Memo

PROJECT: 8429 SE 33RD PL, MERCER ISLAND **DATE:** 3/29/2021

PROJECT NUMBER: 2203-085

To address the comment on replaced hard surface for structures based on the removal of exterior walls down to the foundation or to the subfloor, please see the following:

SHEET NO.
A3.0

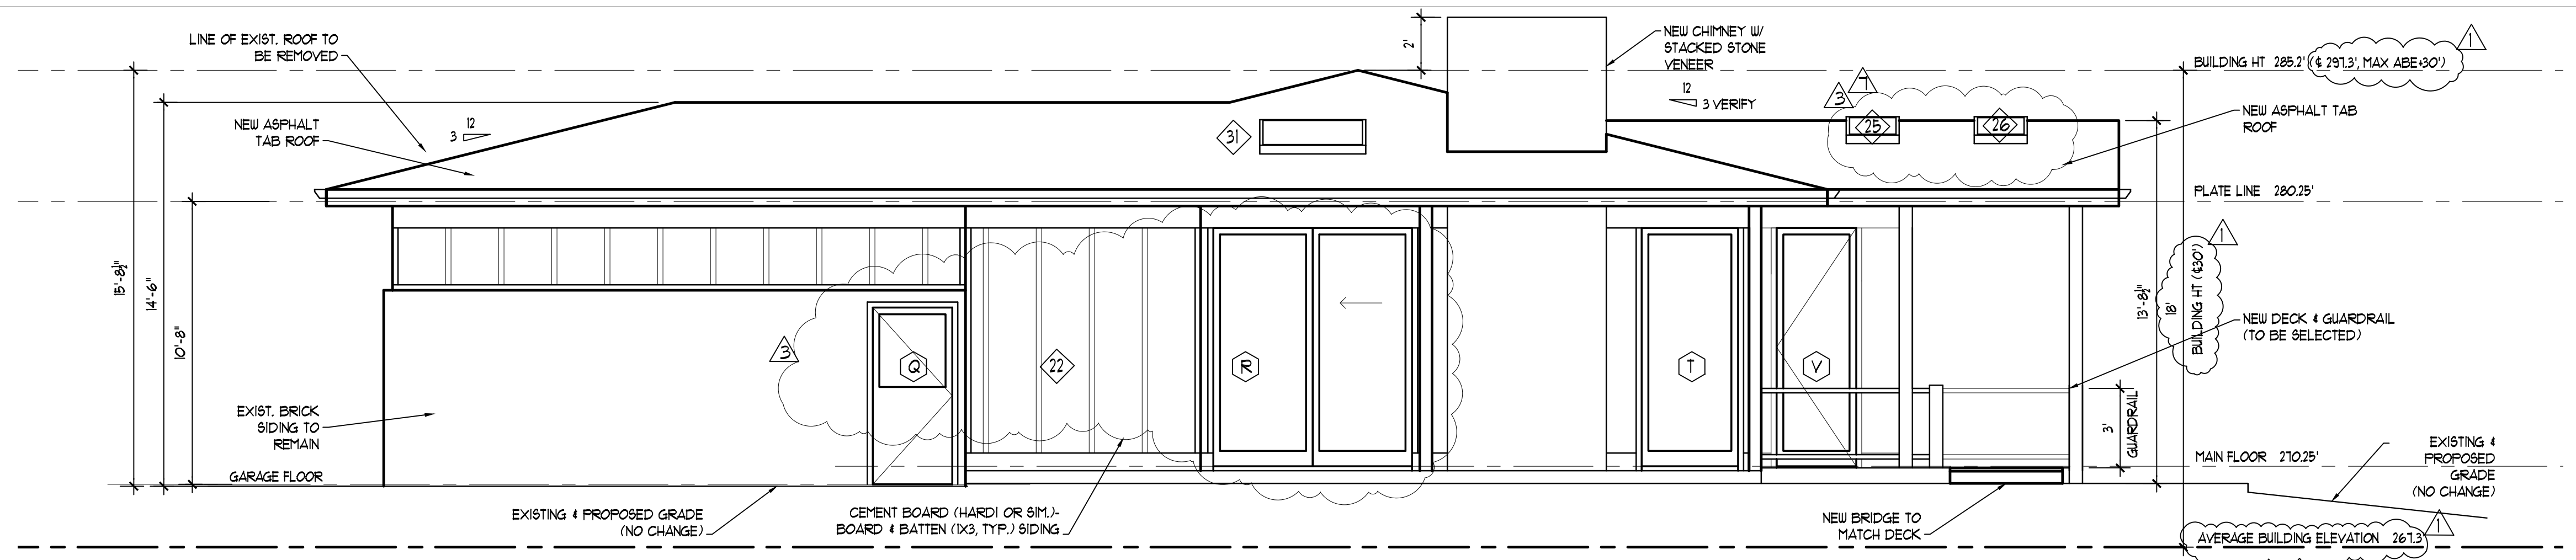
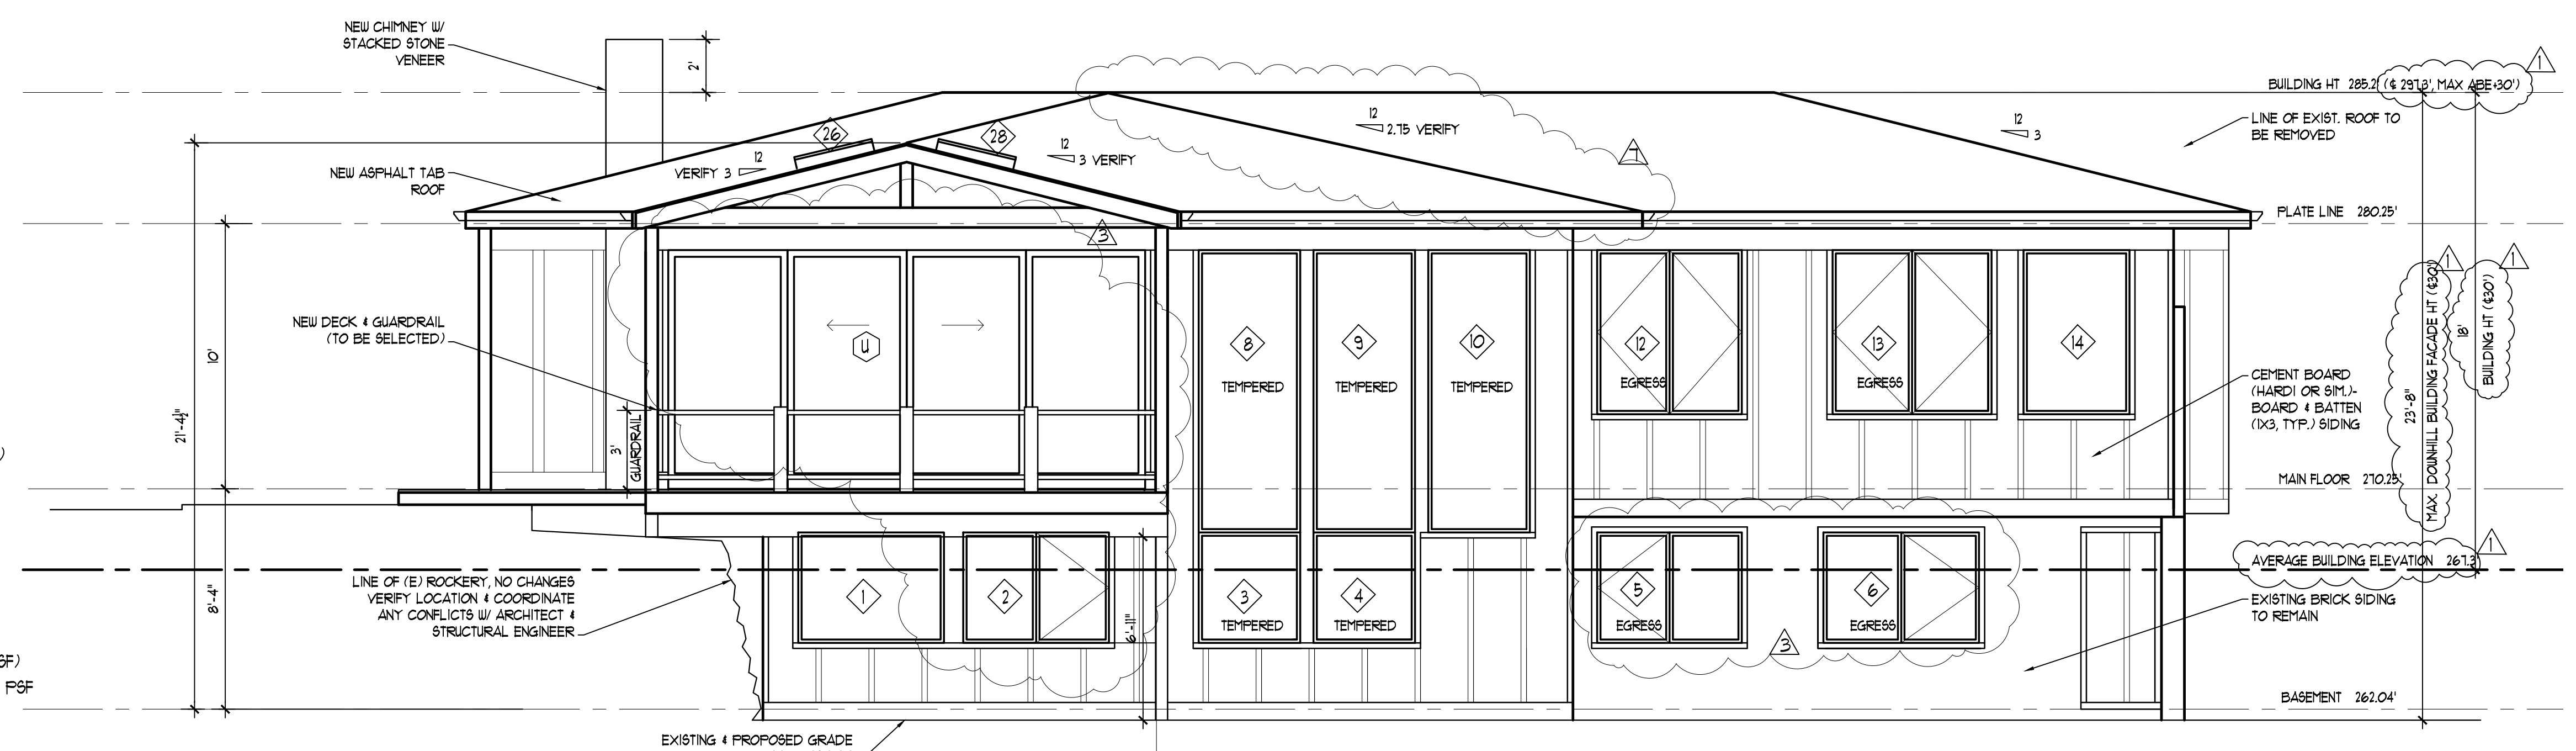
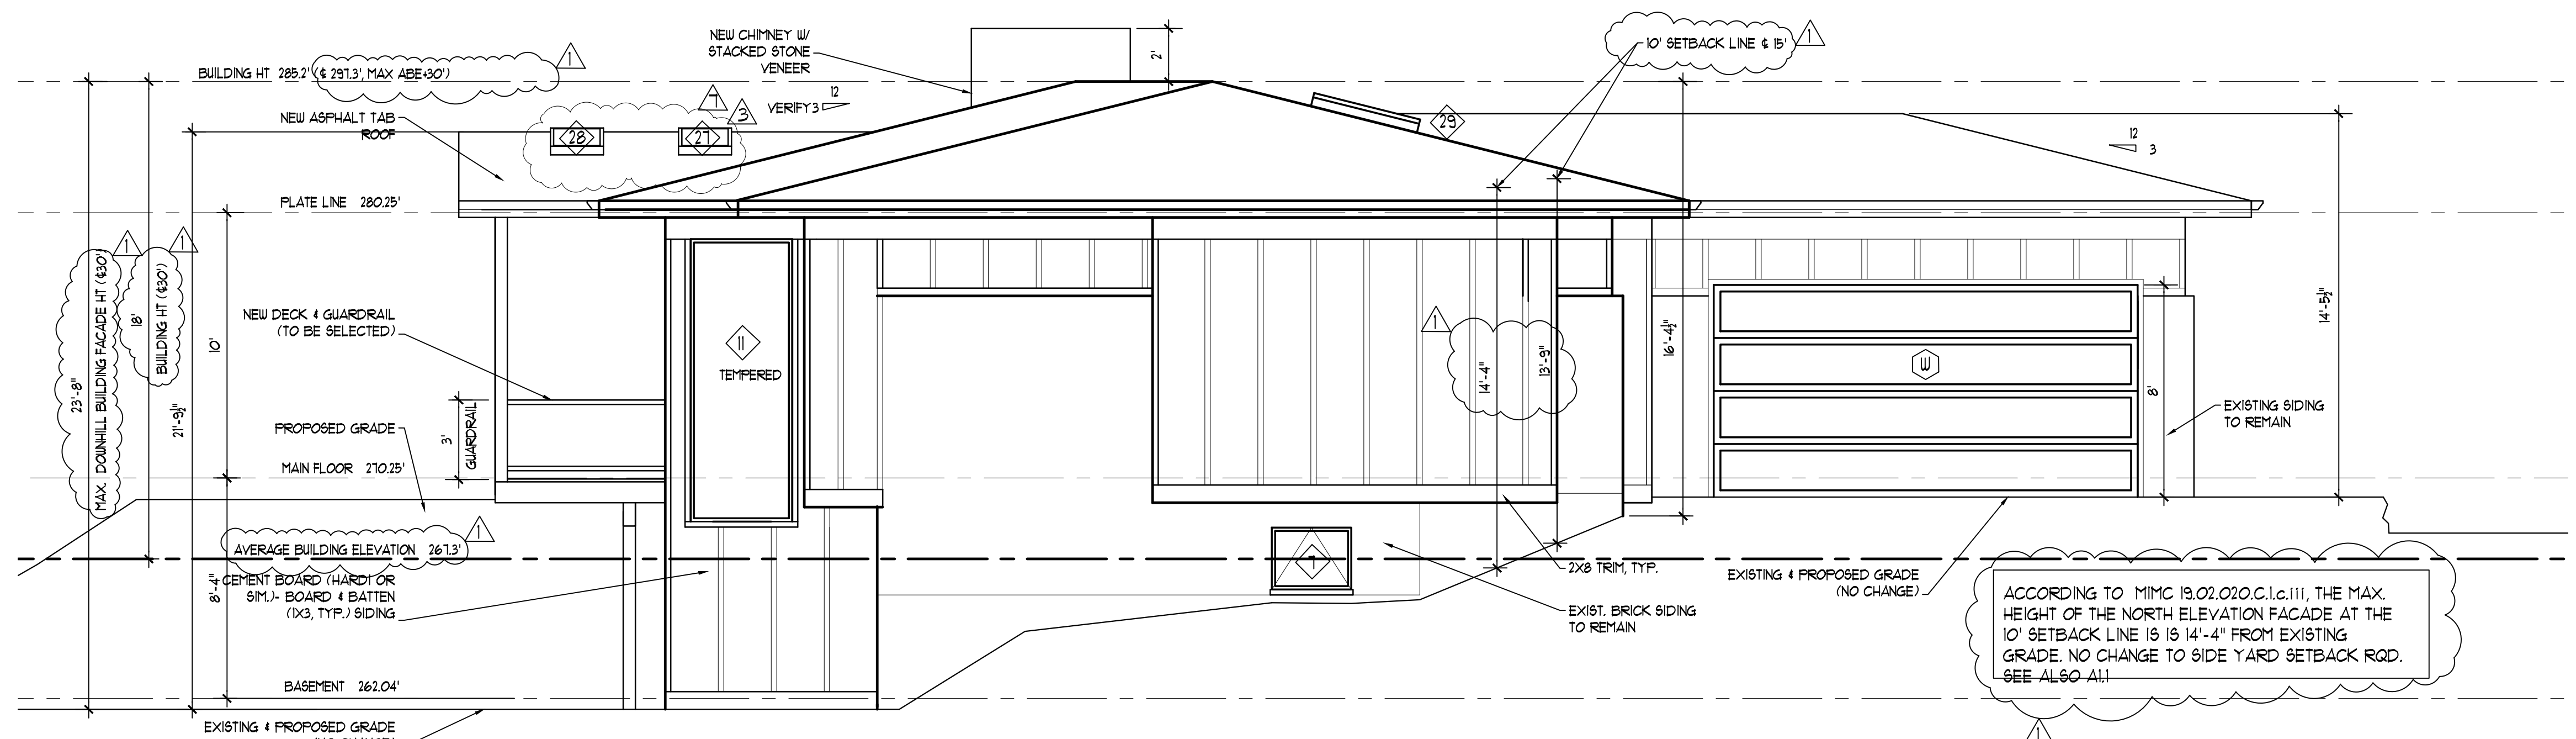
1. Existing elevation drawings, Sheet A3.0 and A3.1, note existing brick siding remain on several of the exterior walls – and show new infill siding above. The existing walls were not intended to be removed but have new studs sistered on to the existing to preserve the existing brick siding while raising the plate height. We have asked the structural engineer to add a detail, see detail 16 on Sheet S9.2.
2. As requested, we have added a diagram on Sheet A2.1 identifying the roof areas supported by new walls as well as identifying beams/girder trusses/etc that define the support. Using area calcs in cad file we have provided calculations of the new/replaced hard surface at the house and included the new concrete patio for a total of: 1939.48 sf. This is under the 2000 sf threshold so we believe we do not require full drainage report/plan by a licensed civil engineer.
